April 5, 2023

**Re: NuVue I-40 and Wyoming
8526 Mountain Rd. NE
Traffic Circulation Layout
Engineer's/Architect's Stamp XX-XX-XX (J20-D028)**

Based upon the information provided in your submittal received 03-17-23, the above referenced plan cannot be approved for Building Permit until the following comments are addressed:

TRAFFIC CIRCULATION
PLAN

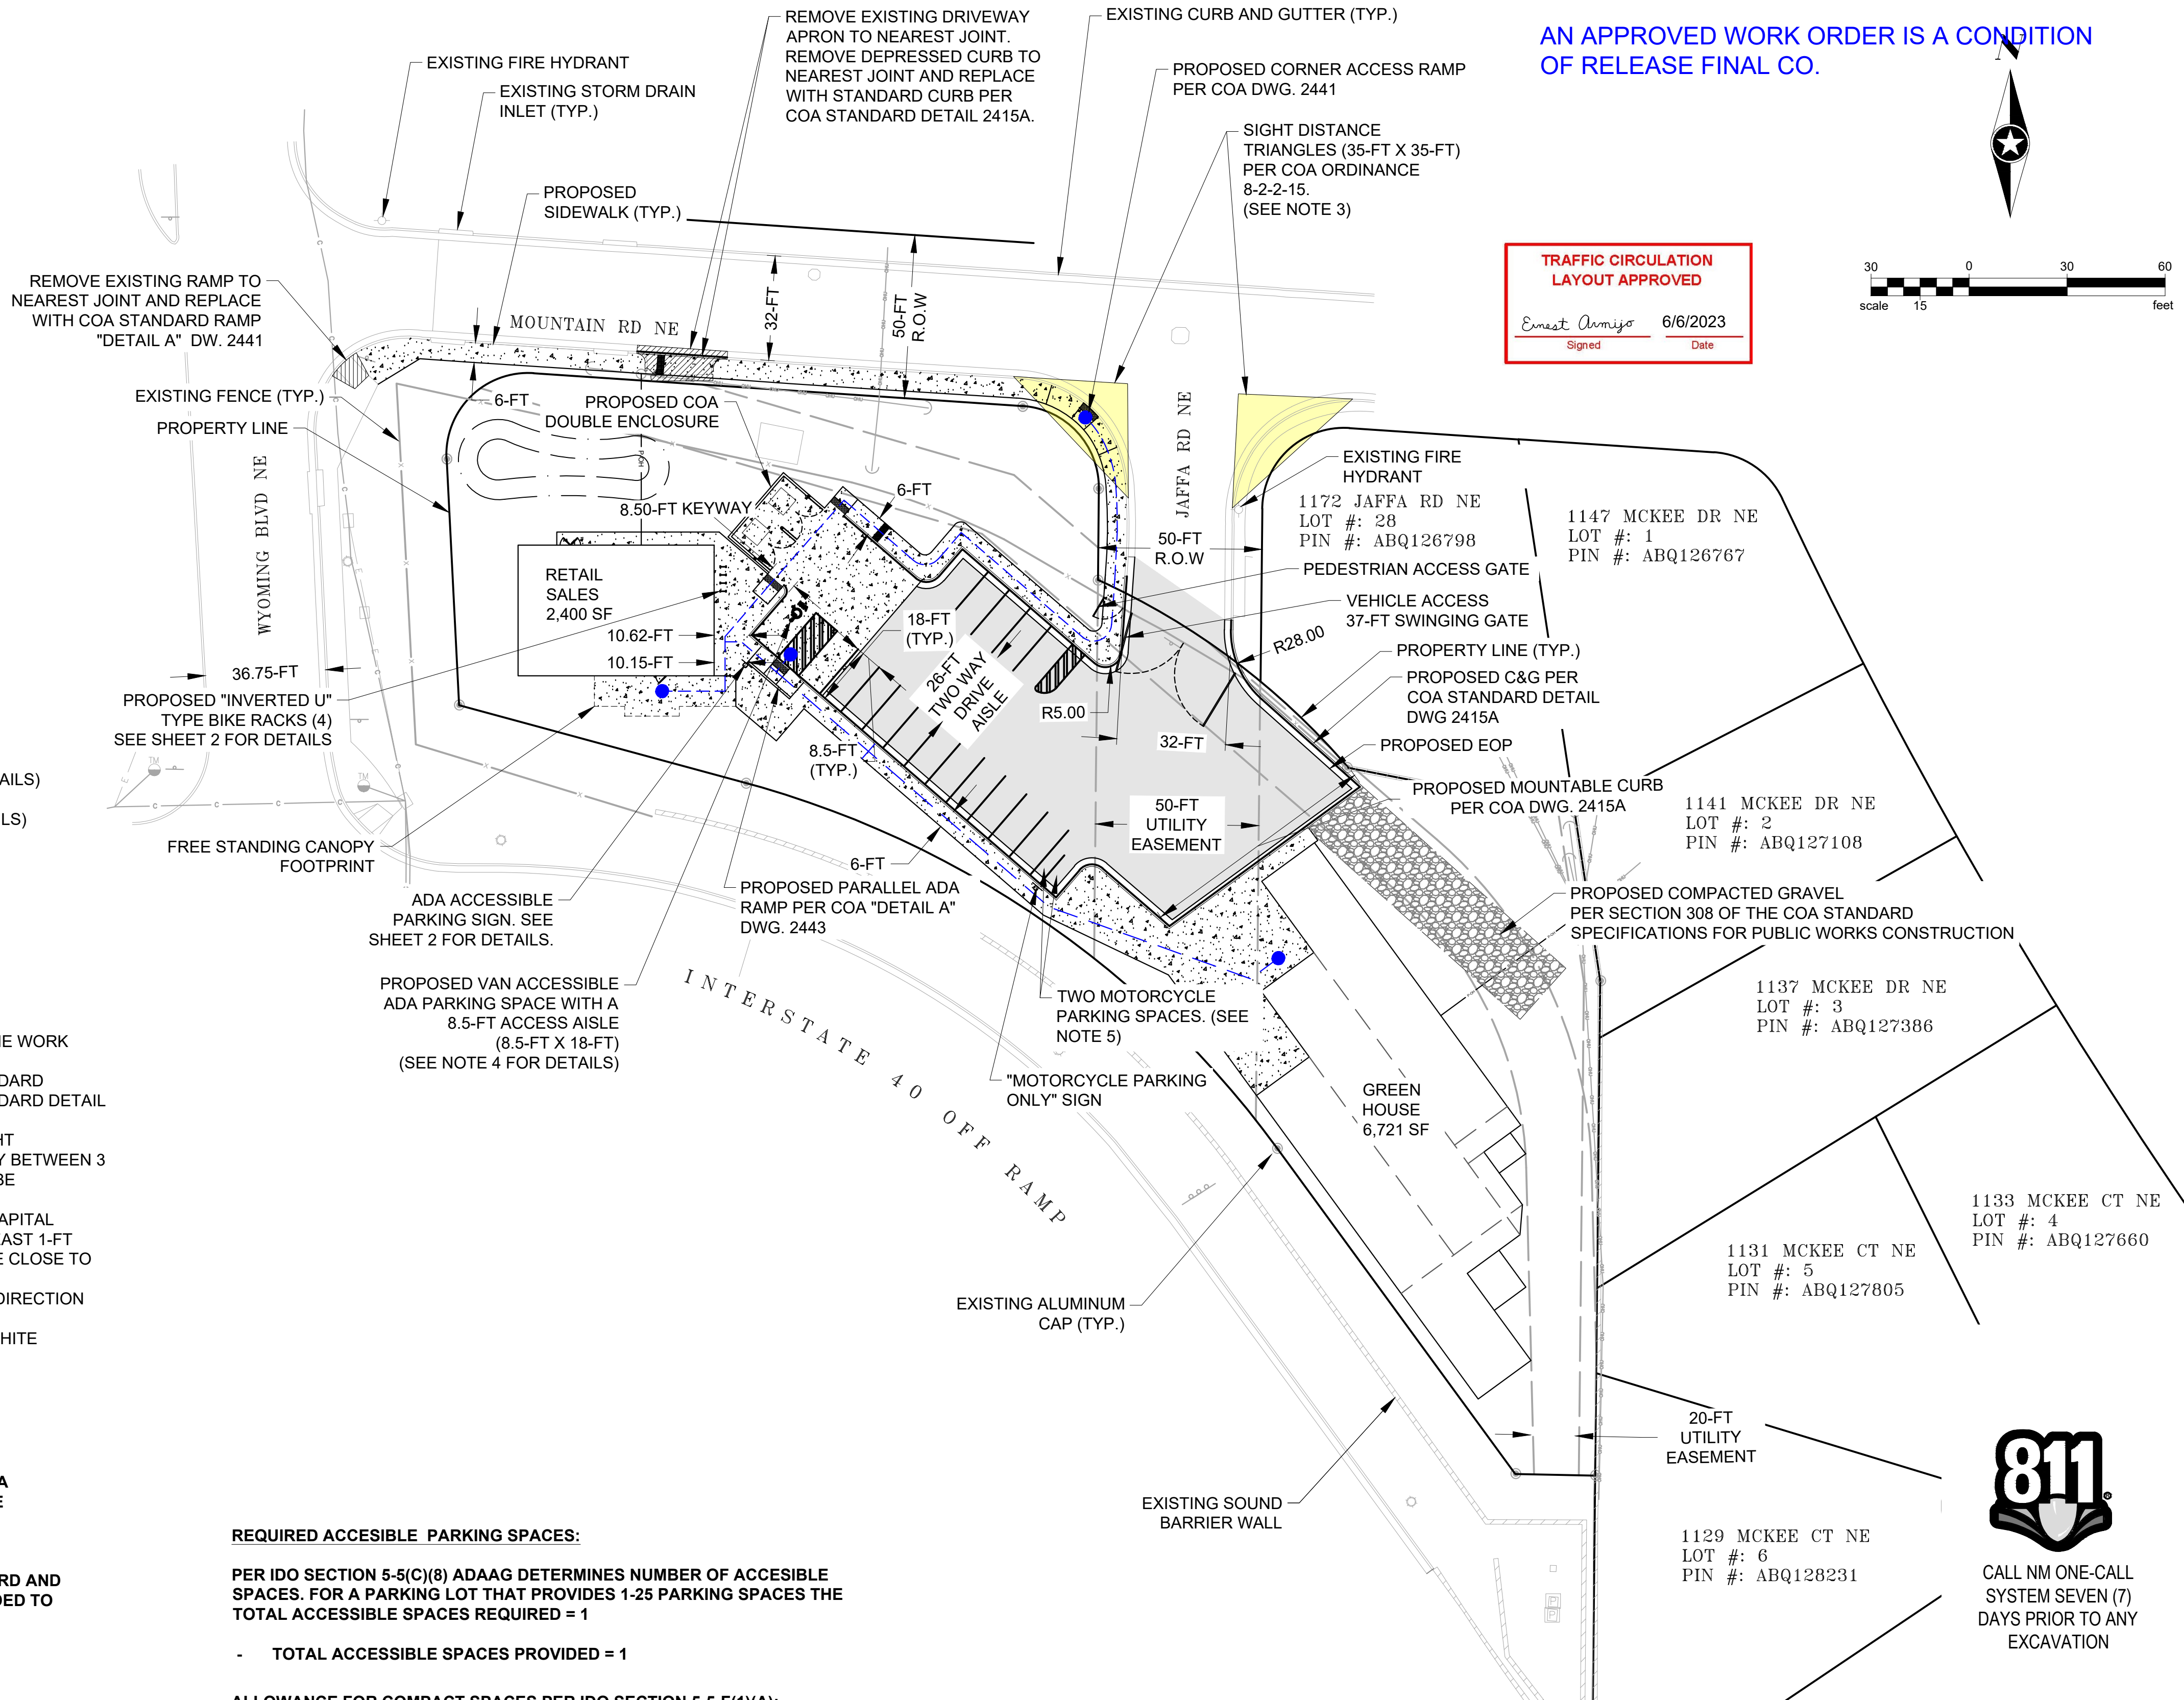
1. Please show a vicinity map showing the location of the development in relation to streets and well-known landmarks.
2. The traffic circulation layout must be stamped, signed, and dated by an engineer or architect licensed in the state of New Mexico.

3. Identify the right of way width, medians, curb cuts, and street widths on Wyoming Blvd. and Mountain Rd.
4. Please define the property line.
5. A 5 ft. sidewalk need to be built along Mountain Rd. from property line to property line. For sidewalk waiver, please contact Ernest Armijo earmijo@cabq.gov

6. Please remove the compact parking spaces because it's allowed when 20 or more parking spaces are provided.
7. Please provide details for all the proposed ADA ramp, signs, Bike Rack, and pavement marking.

8. The ADA accessible parking sign must have the required language per 66-7-352.4C NMSA 1978 **"Violators Are Subject to a Fine and/or Towing."** Please call out detail and location of signs.

9. The ADA access aisles shall have the words **"NO PARKING"** in capital letters, each of which shall be at least one foot high and at least two inches wide, placed at the rear of the parking space so as to be close to where an adjacent vehicle's rear tire would be placed. (66-1-4.1.B NMSA 1978)

10. ADA curb ramp at the corner of Wyoming and Mountain must be updated to current standards and have truncated domes installed.
11. Motorcycle parking spaces shall be designated by its own conspicuously posted upright sign, either free-standing or wall mounted per the zoning code.

12. The pavement marking "MC" should be shown in the opposite direction for Motorcycles entering the parking space.
13. All bicycle racks shall be designed according to the following guidelines:

14. Bicycle racks shall be sturdy and anchored to a concrete pad.
15. A 1-foot clear zone around the bicycle parking stall shall be provided.
16. Bicycle parking spaces shall be at least 6 feet long and 2 feet wide.

17. A 5 ft. keyway is required for dead-end parking aisles. Please show this dimension on the site plan.

18. Per the IDO, a 6 ft. wide ADA accessible pedestrian pathway is required from the public sidewalk to the building entrances. Please clearly show this pathway and provide details.

19. Per DPM, a 6 ft. wide ADA accessible pedestrian pathway is required from the ADA parking stall access aisles to the building entrances. Please clearly show this pathway and provide details.

20. ADA accessible pedestrian pathway should not be placed behind parking space or adjacent to a vehicular way. Vehicle and pedestrian/wheel chair conflicts should be avoided as much as possible.

21. Refuse vehicle maneuvering shall be contained on-site. The refuse vehicle shall not back into the public right of way.; provide a copy of refuse approval.

22. Provide a copy of Fire Marshal approval.
23. It is not apparent what type of pavement surface is being proposed. A hard driving surface will be required as part of this proposed project for parking area and drive aisles.

24. Show the clear sight triangle and add the following note to the plan: "Landscaping and signage will not interfere with clear sight requirements. Therefore, signs, walls, trees,

and shrubbery between 3 and 8 feet tall (as measured from the gutter pan) will not be acceptable in the clear sight triangle.

25. Please specify the City Standard Drawing Number when applicable.
26. Please add a note on the plan stating "All improvements located in the Right of Way must be included on the work order."
27. Add a note stating "All broken or cracked sidewalk must be replaced with sidewalk and curb & gutter." A build note must be provided referring to the appropriate City Standard drawing.
28. Traffic Studies: See the Traffic Impact Study (TIS) thresholds. In general, a minimum combination of 100 Vehicles entering and exiting in the peak hour warrants a Traffic Impact Study. Visit with Traffic Engineer for determination, and fill out a TIS Form that states whether one is warranted. In some cases, a trip generation may be requested for determination (Contact Matt Grush: mgrush@cabq.gov).
29. Please provide a letter of response for all comments given.
